Gatwick Airport Northern Runway Project

The Applicant's Response to Deadline 2 Submissions

Application Document Ref: 10.17

Table 3 The Applicant’s Response to the Matters Raised by AIPUT on the Surface Access Highways Plans – Structure Section Drawings – For Approval

Project Code-Location-Discipline-Volume-Type-Unique Number
41700- XX -B -LLO - GA - 200175

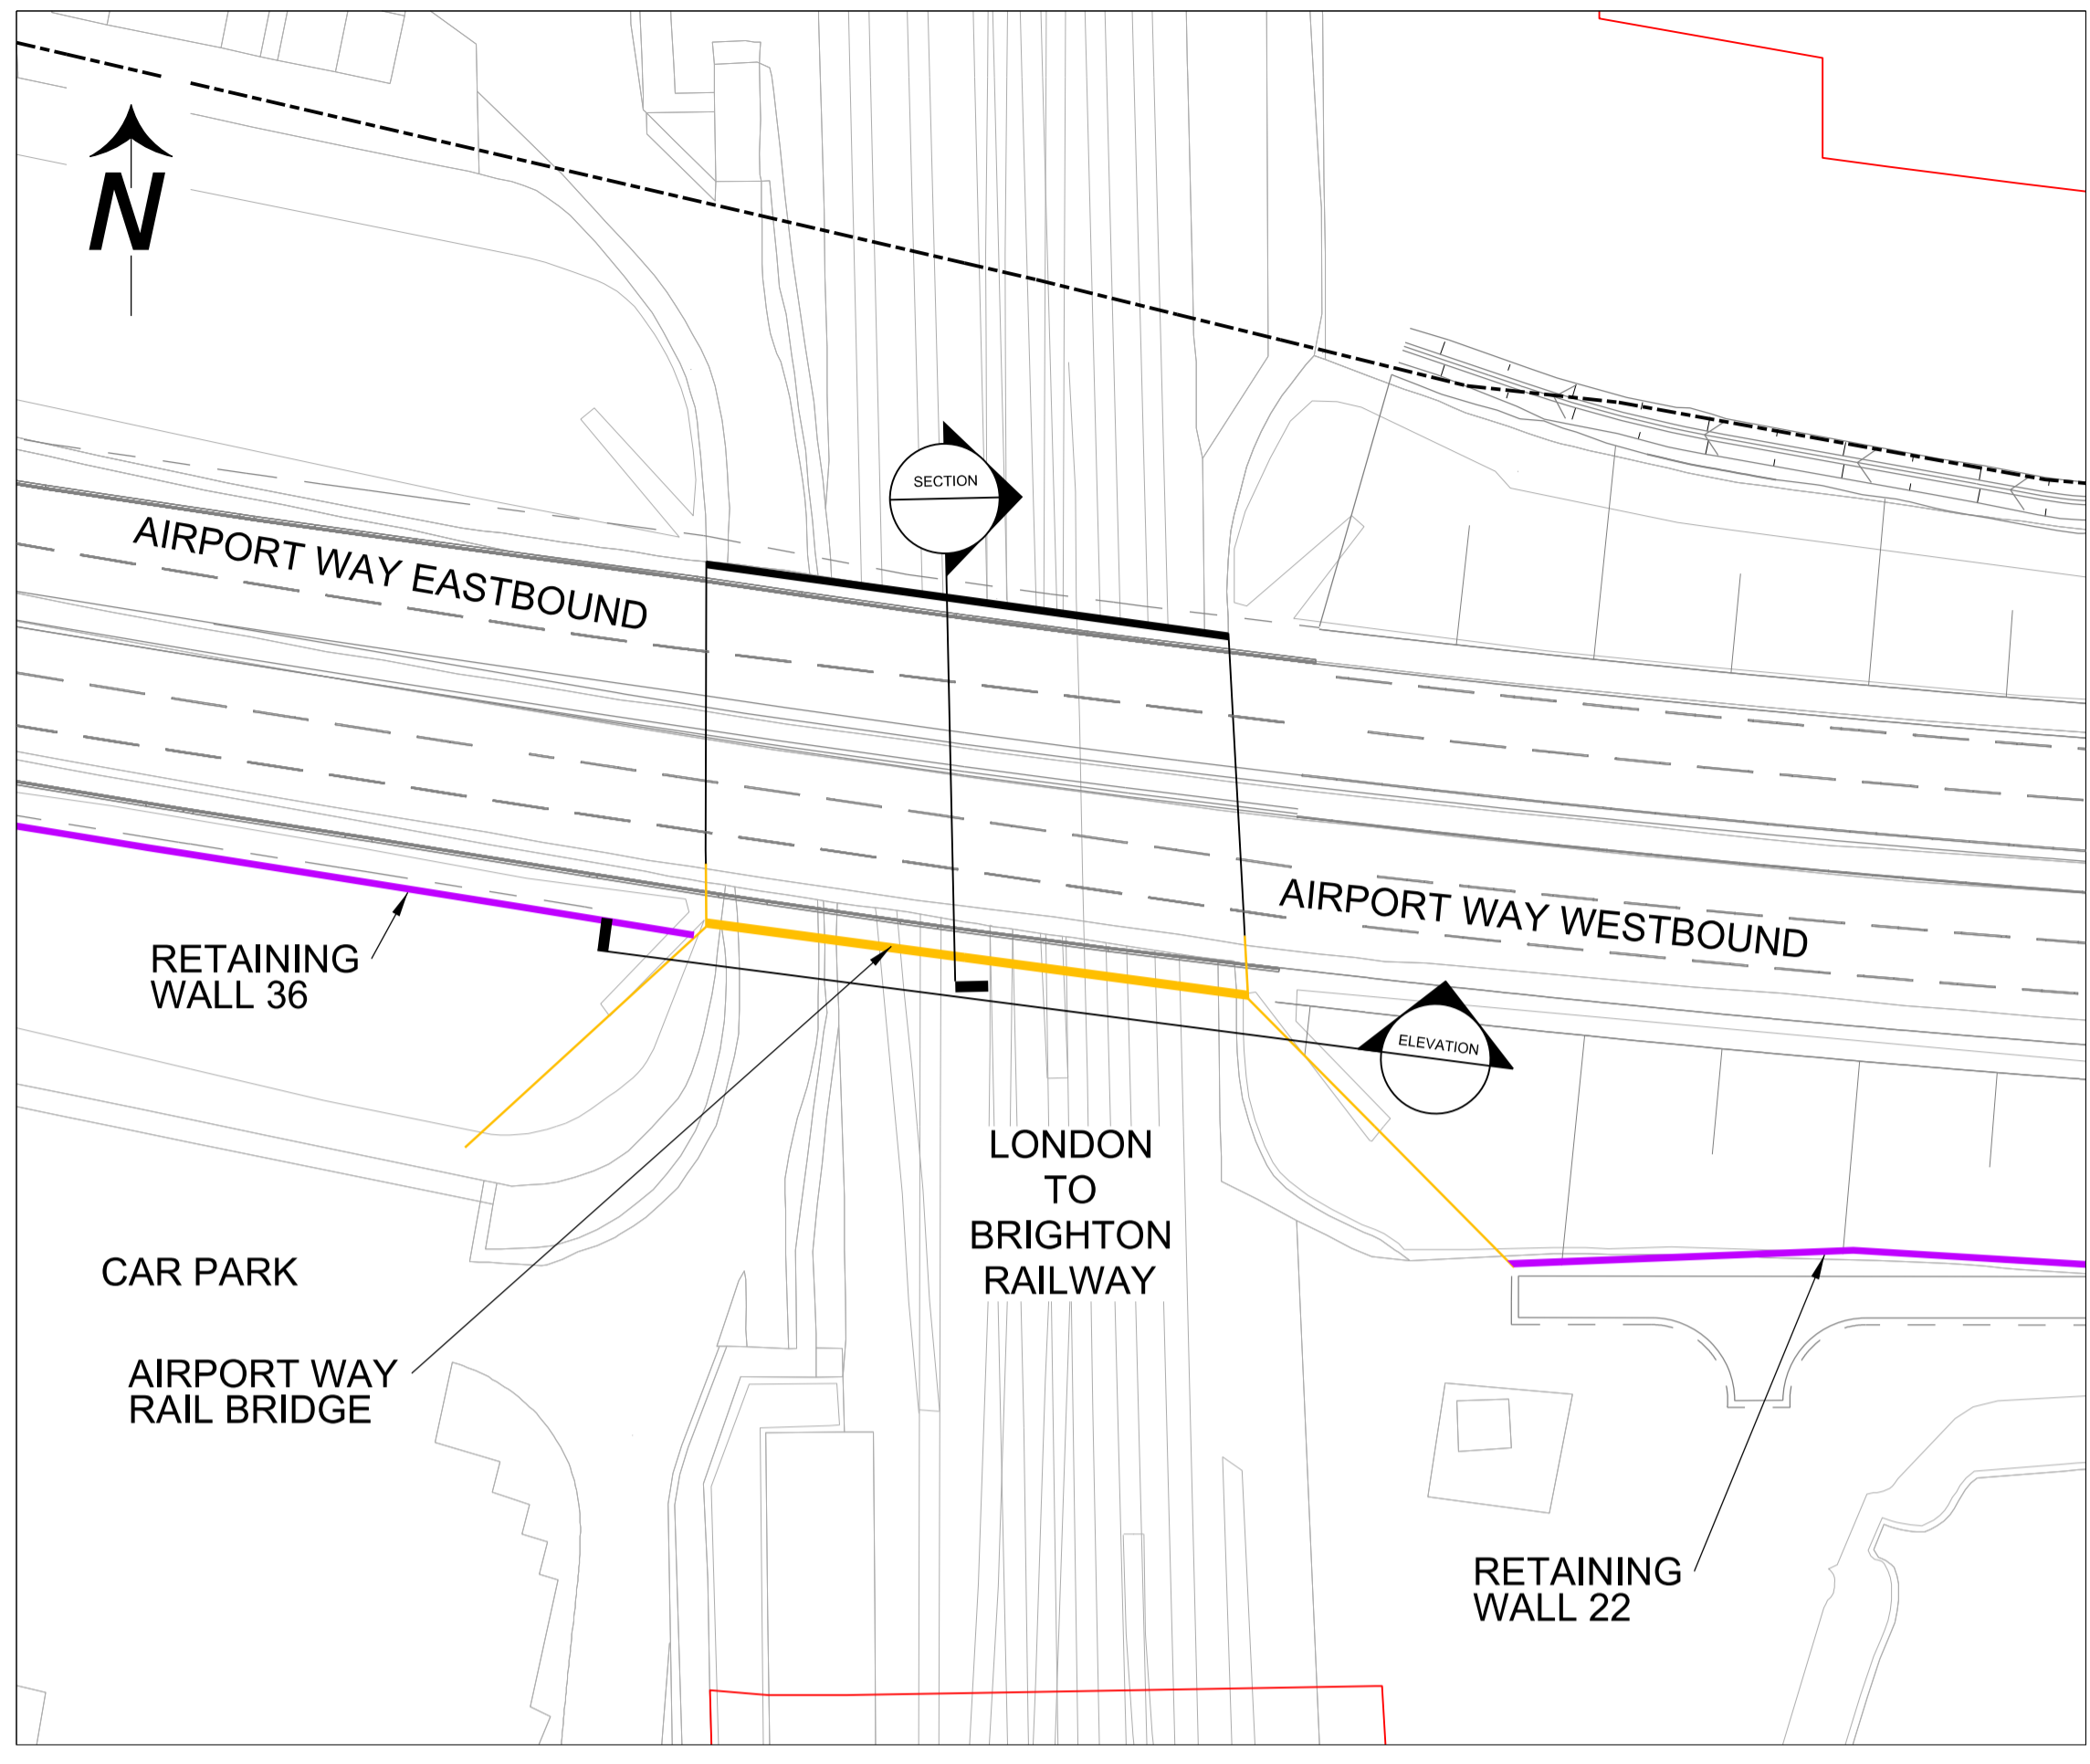
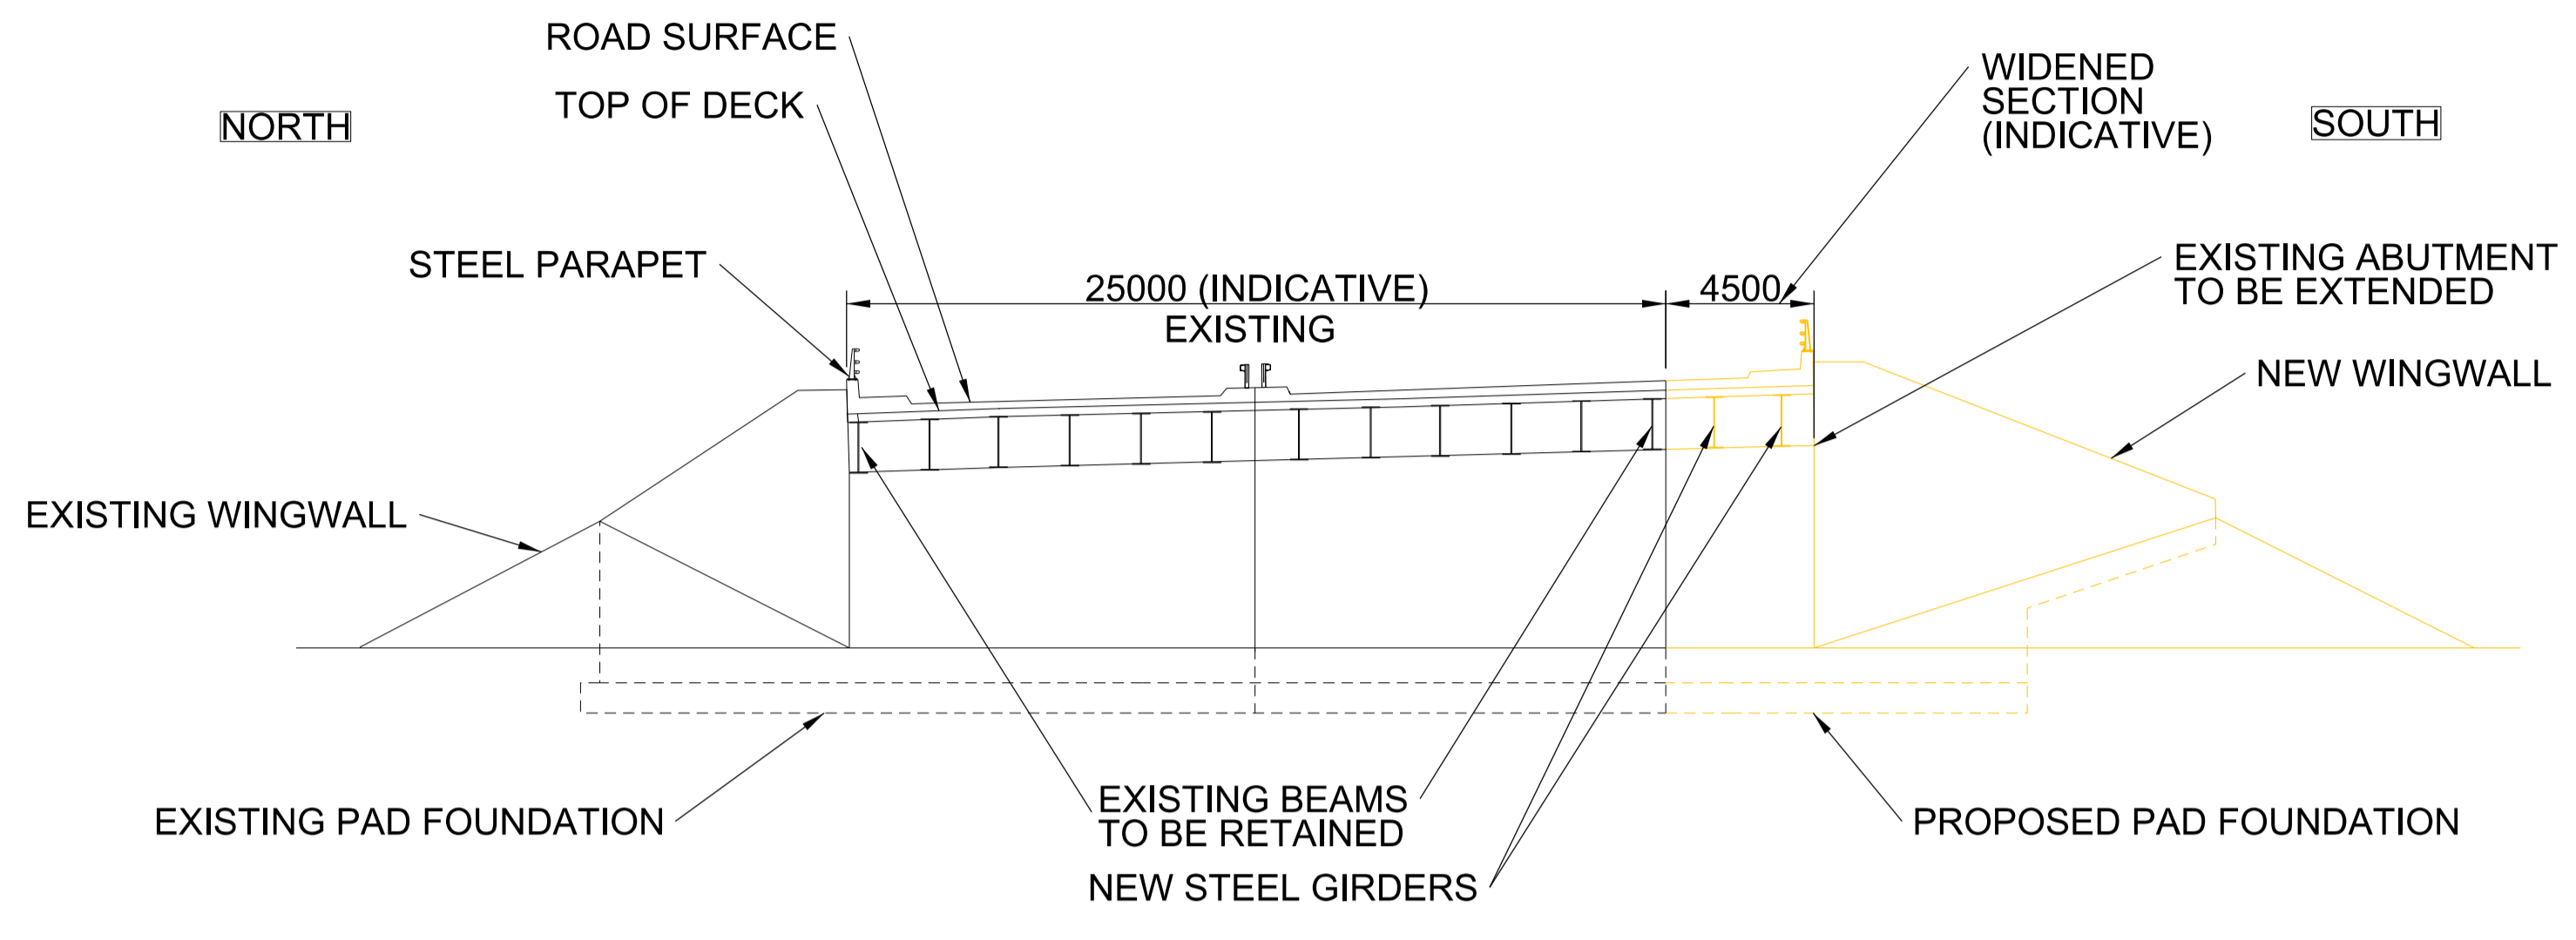
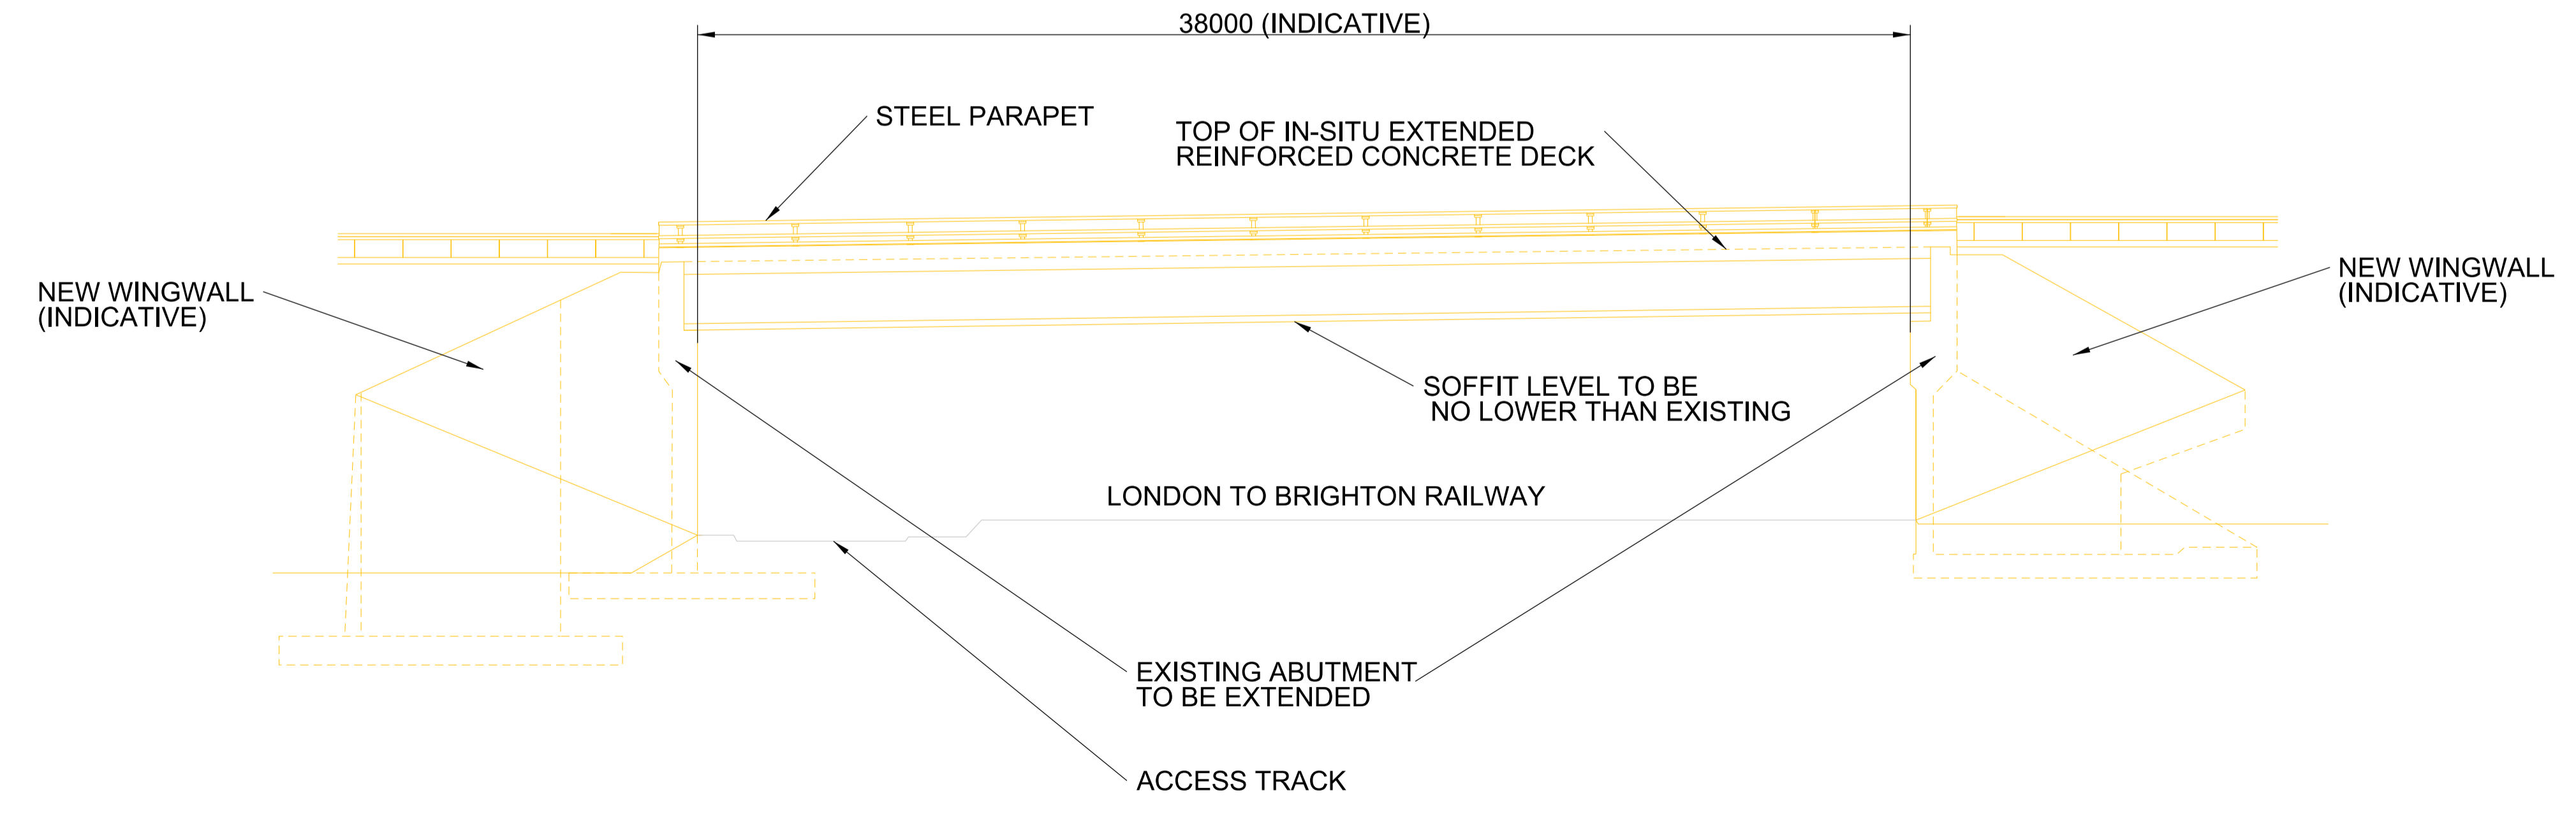
Ref	Matter Raised	The Applicant’s Response
N/A	<p>The structure section drawings are welcomed by AIPUT and provide some detail to the surface access highway plans being proposed. Motion would like to query on behalf of AIPUT, how the lane widths have been determined. For instance, the two-way single carriage ways are labelled as 7.25m despite a width of 7.3m being the established DMRB requirement, suggesting unfamiliarity with DMRB. AIPUT would also request that dimensioned plans are provided for junctions across the highway network.</p>	<p>It is assumed that the carriageway cross section being referred to is the proposed North Terminal Flyover Link cross section illustrated in Sheet 5 of the Surface Access Highways Plan – Structure Section Drawings (Doc Ref. 4.8.3 v3). This is proposed to be a one way carriageway that is to provide connectivity between Airport Way Westbound and A23 London Road Northbound. The link cross section at the North Terminal Flyover Bridge is comprised of a 3.7m wide single traffic lane for northbound traffic plus a 3.3m wide nearside hard shoulder provision and a 0.3m wide offside hardstrip in line with the DMRB CD 127 'Cross-sections and Headrooms' requirements for an urban all-</p>

purpose connector road. The cross section on Sheet 5 of the **Surface Access Highways Plan – Structure Section Drawings** (Doc Ref. 4.8.3 v3) is being amended at Deadline 3 to correct the typo in the 7.25m carriageway dimension label and confirm the proposed 7.3m wide carriageway provision.
